Charlotte Department of Transportation

Memorandum

Date: October 28, 2008

Subject: Rezoning Petition 08-140: Located on the east side of Park Road between Sharon Road and Wolfe Ridge Road (revised 10/17/08)

1-1 SCHEMATIC SITE PLAN
Z1 SCALE: 1" = 50'-0"

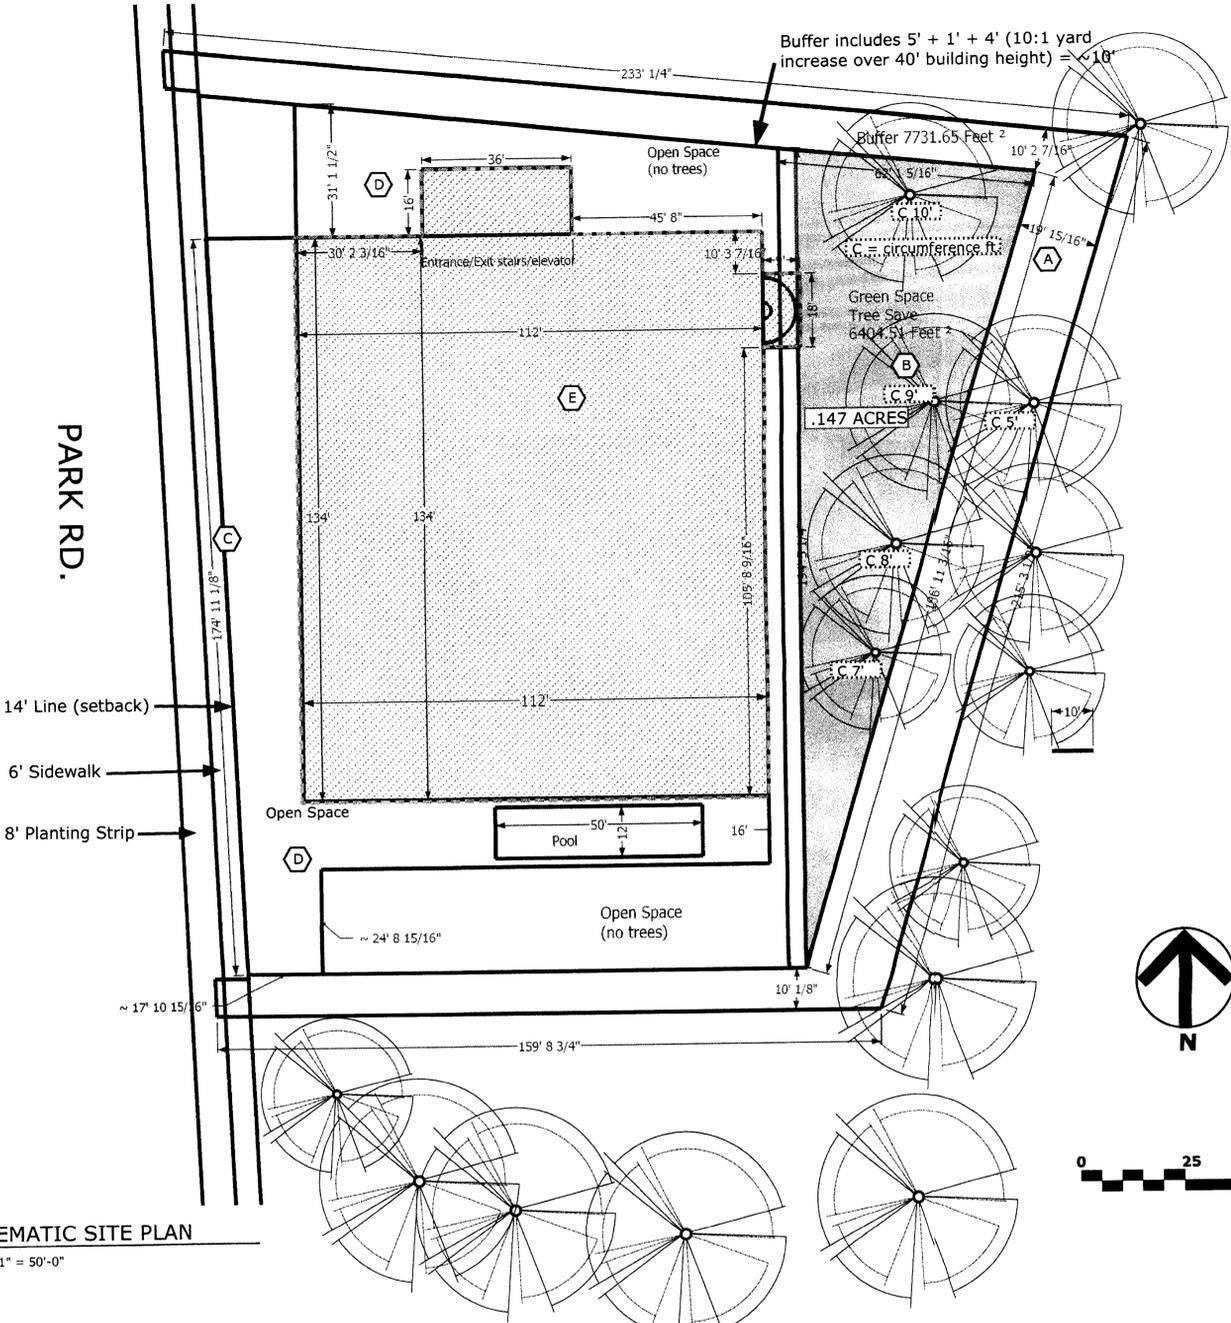
1. Due to the proposed density for this site and deficiency of connectivity with the surrounding area, we request that a new public street be provided along the northern property boundary of the site, stubbing to the eastern property boundary. Access to the site will be from a driveway to this new public street. (*Previous Comment-2*)
2. The requested public street needs to be designed as a Local Residential Street – Wide in accordance with the Urban Street Design Guidelines (USDG). This typical cross-section includes a 35-foot back-of-curb width with a 20-foot wide two-way mixed vehicle zone

3. The site plan should acknowledge and note that in the urban residential zoning district building setbacks are required to be measured from the back of either an existing or future curb-line. CDOT has determined that the proposed curb-line for Park Road will be located 4 feet behind the existing curb-line. This should be noted and illustrated on the conditional site plan. (*Previous Comment-2*)

Adequate sight triangles must be reserved at the existing/proposed street entrance(s). Two 35' x 35' sight triangles are required for the entrance(s) to meet requirements. All proposed trees, berms, walls, fences, and/or identification signs must not interfere with sight distance at the entrance(s). Such items should be identified on the site plan.

- Meet applicable standards in the Charlotte Land Development Standards Manual (latest revision).
- Dimension width of the existing and proposed driveways.
- Indicate the locations and widths of all adjacent and opposing driveways.
- Indicate typical parking module dimensions.
- Include a parking summary with figures for the numbers of parking spaces required and provided.
